PLANNING CONSULTATION REPLY

APPLICATION: The Vicarage, St Pauls, Burton Road, Monk Bretton, S71 2HQ.

2 0 2 3 0 6 2 7

T1 - Horse Chestnut

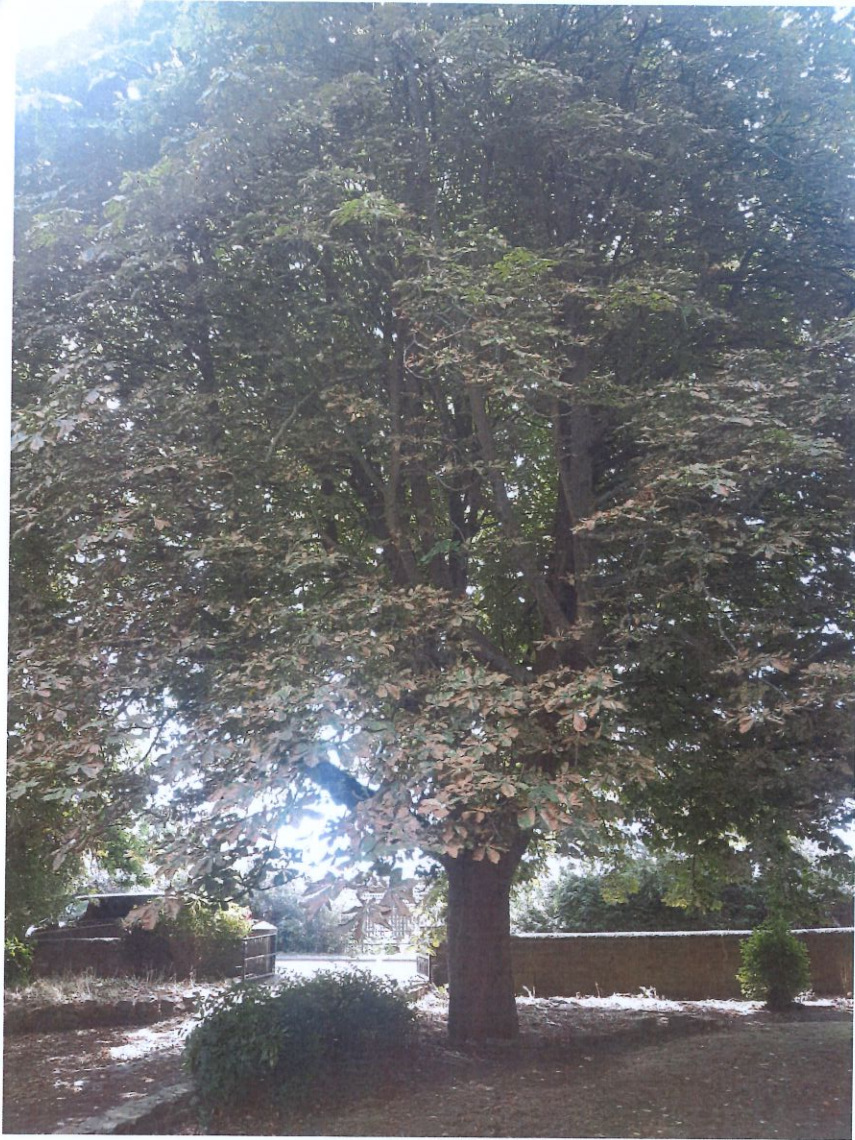
The tree is a very large mature Horse chestnut tree located in the front garden of the property and has very high amenity value due to its size and prominence.

The works proposed are to reduce back the branch tips to give 3m clearance over the lawn and 4m over the driveway along with a light 15% crown thin. It has been some time since the tree has been worked on and the canopy is very dense, likewise the crown does hang very low. The works proposed are therefore entirely sensible and will not be of any detriment to the tree when undertaken carefully. Therefore there is no objection to the proposal from an arboricultural perspective.

The works applied for are appropriate and as such there is no issue with this application.

APPROVE: the works as described in the application document.
